Subject: RE: Attached letter from Kirklees Council regarding application number confirmation that the proposed attenuation tanks is not located under an adoptable highway and at location land at, Owl Lane, Chidswell, Dewsbury

Bridges & Structures Manager
Structures Section
Highways and Streetscene
Kirklees Council

**MASS CONCRETE HIGHWAY RETAINING WALL
(500mm RETAINED HEIGHT)**
(1:20)

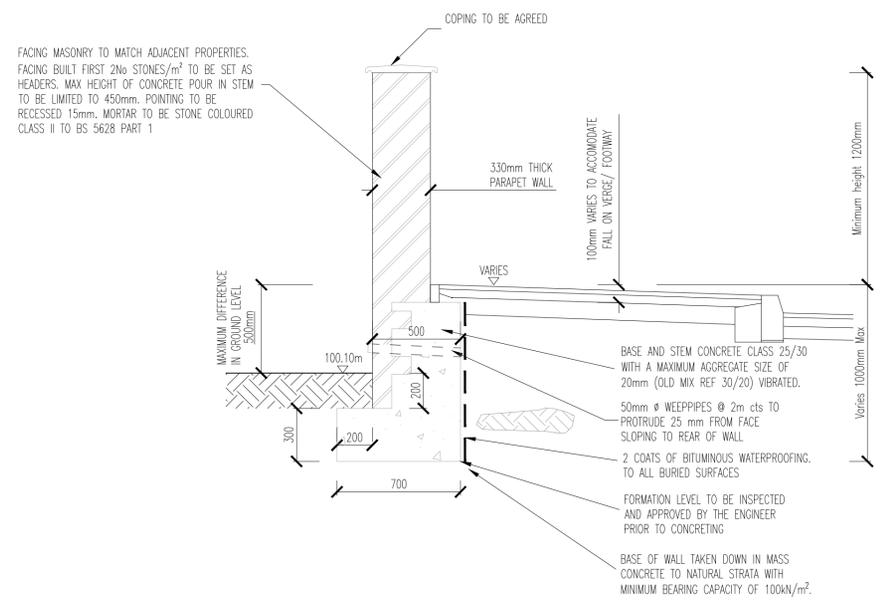
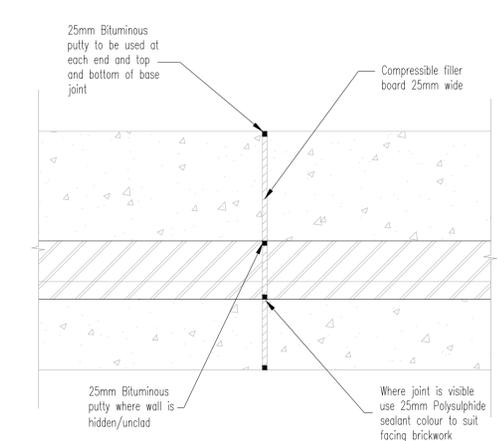
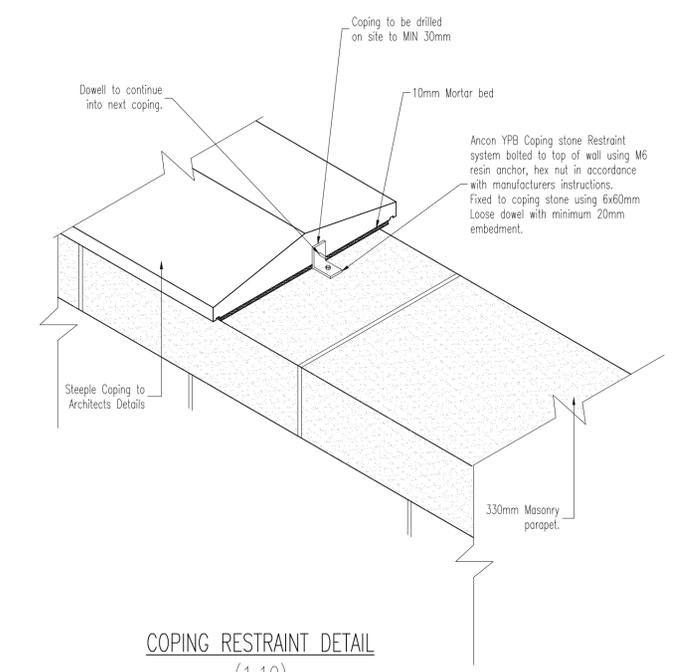
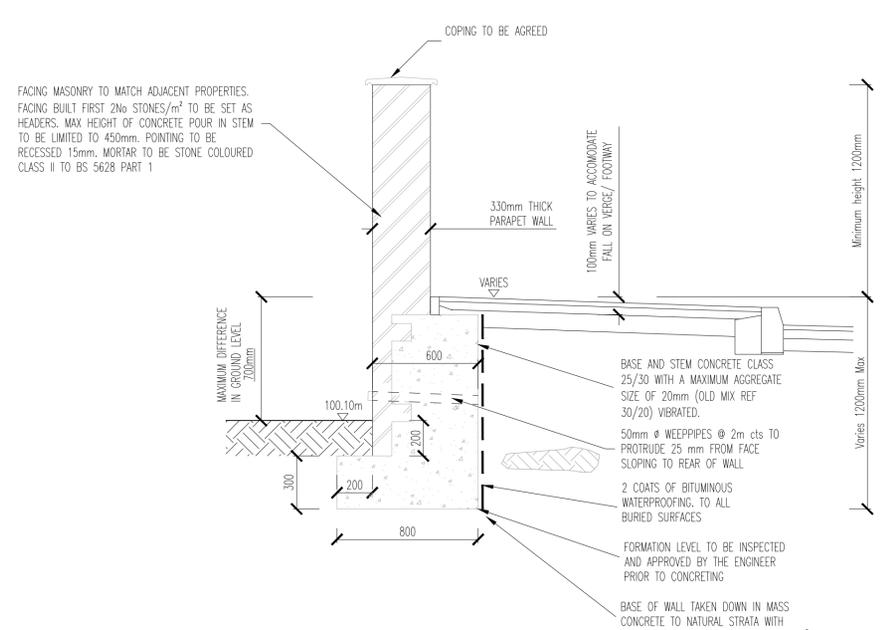
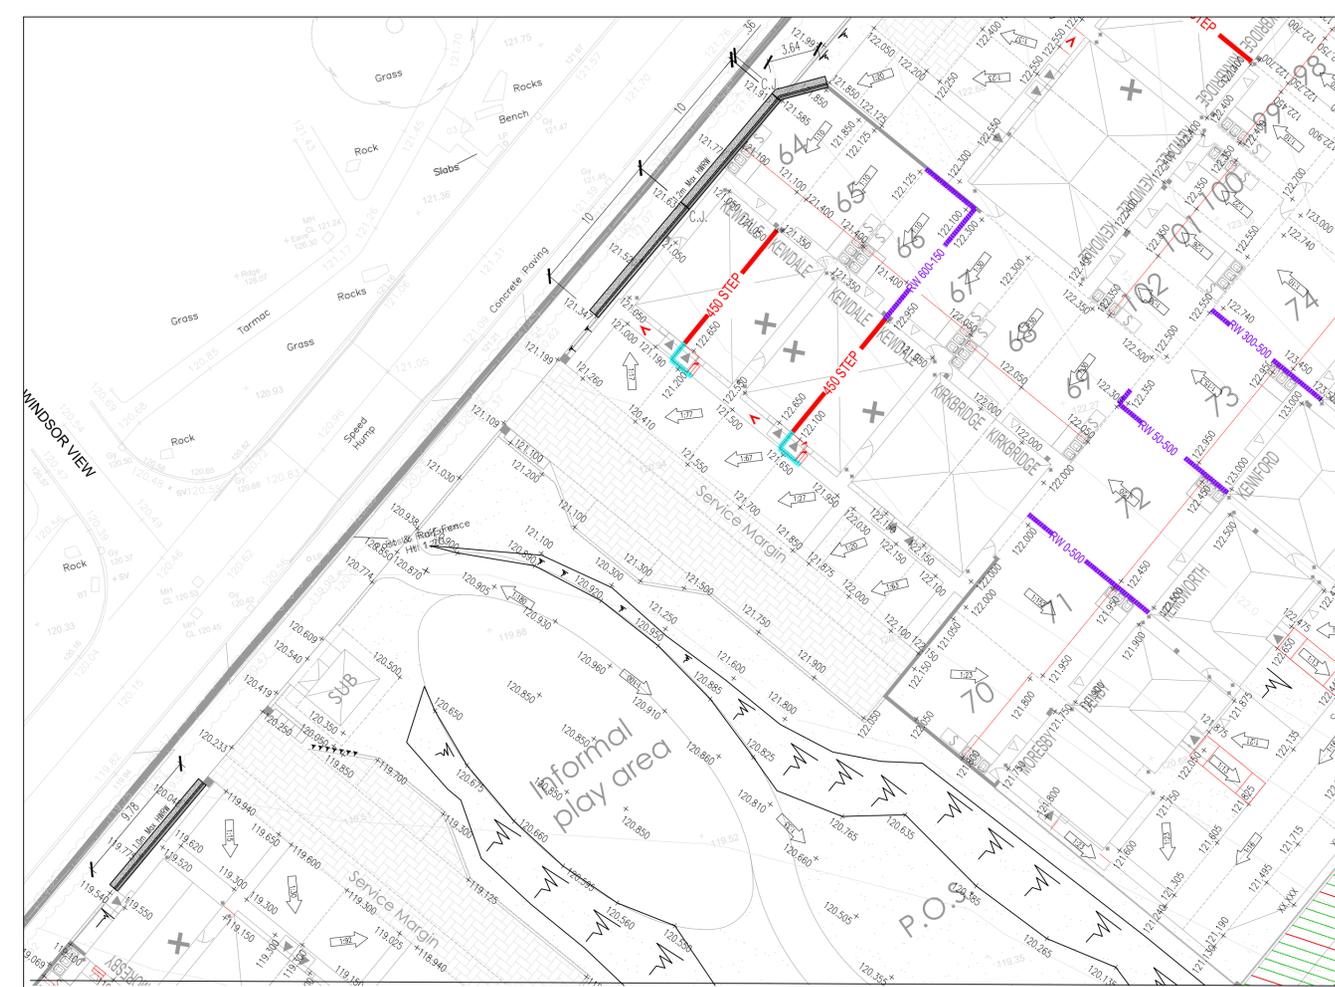
I would like to advise that condition 10 pertaining to the design of new retaining walls at the above site can not be discharged pending the successful completion of the technical approval for their design (via submission of AIPs), which has yet to commence.
